Following on from our exchange of e-mails below, please find attached an updated copy of the engineer's drawings/details for review by you and your Drainage Engineer.

Subject: AB/63/20/DOC

We have the following comments regarding condition 9:

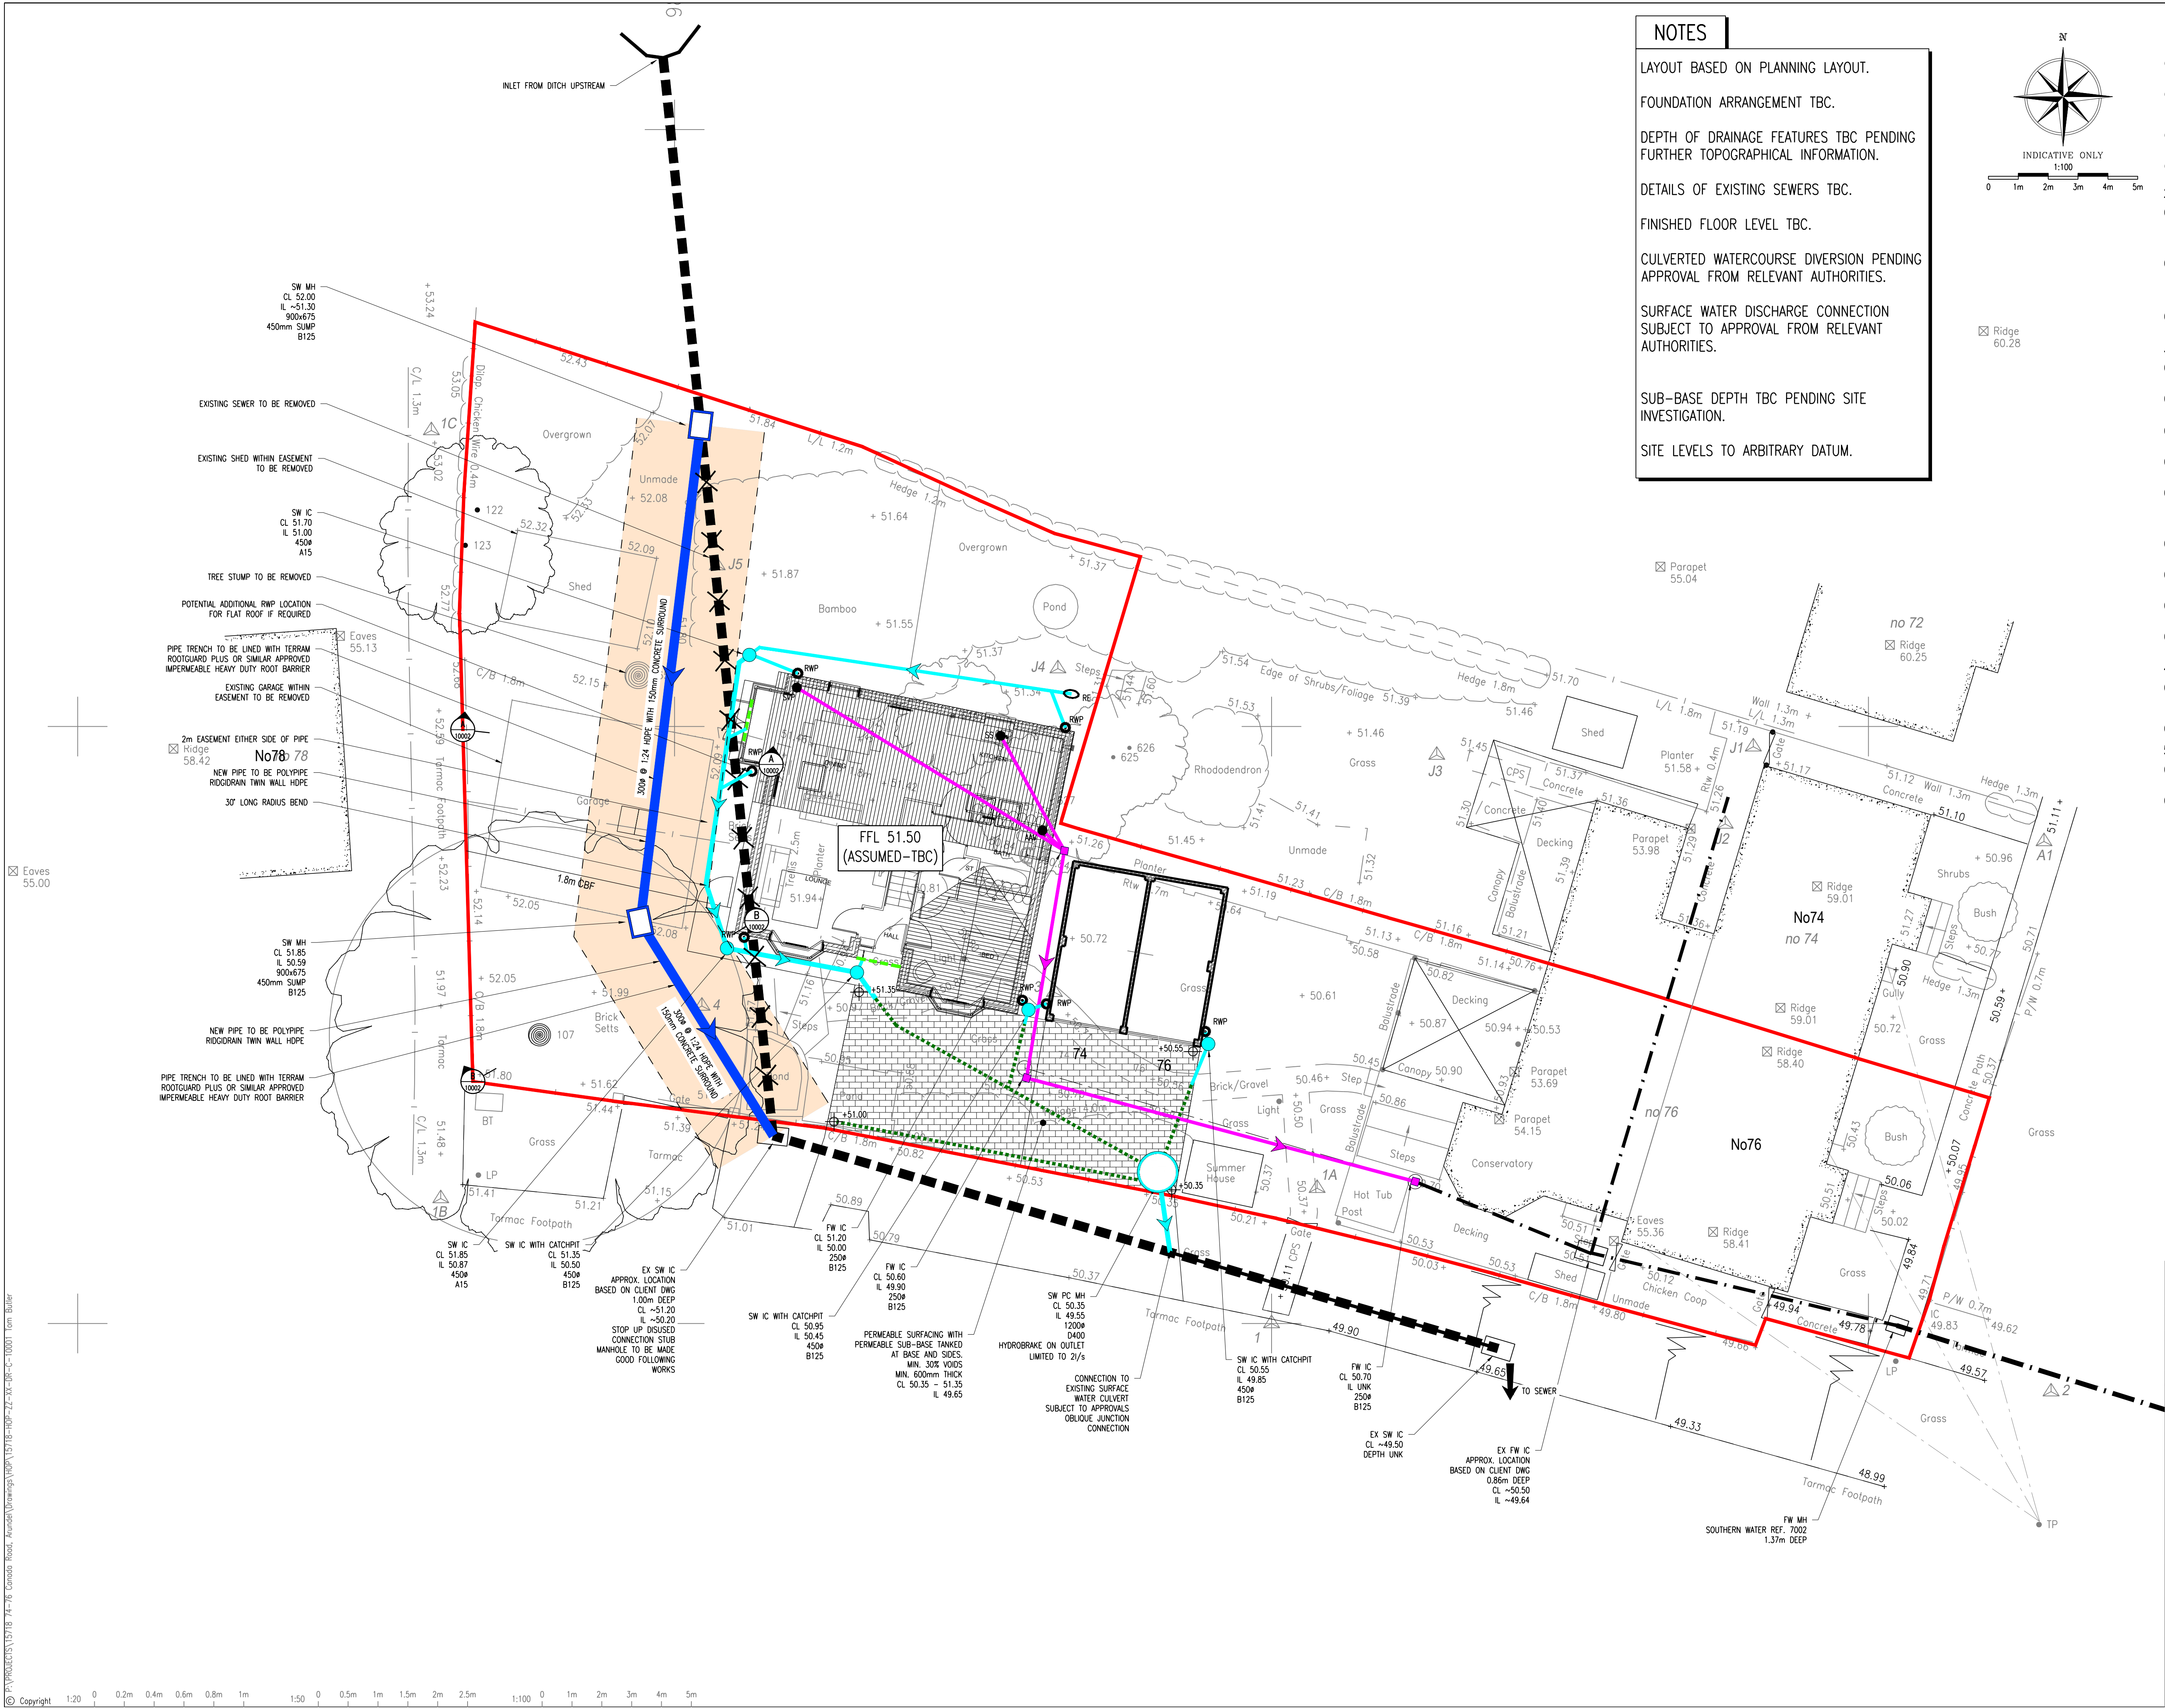
1. Please can a site specific construction detail drawing of the hydrobrake be provided.
2. Please adjust layout to include silt traps prior to all connections to permeable paving on plan.
3. Please provide finish and formation levels of permeable paving.
4. Please provide dimensions and construction detail for permeable pipe through sub-base.
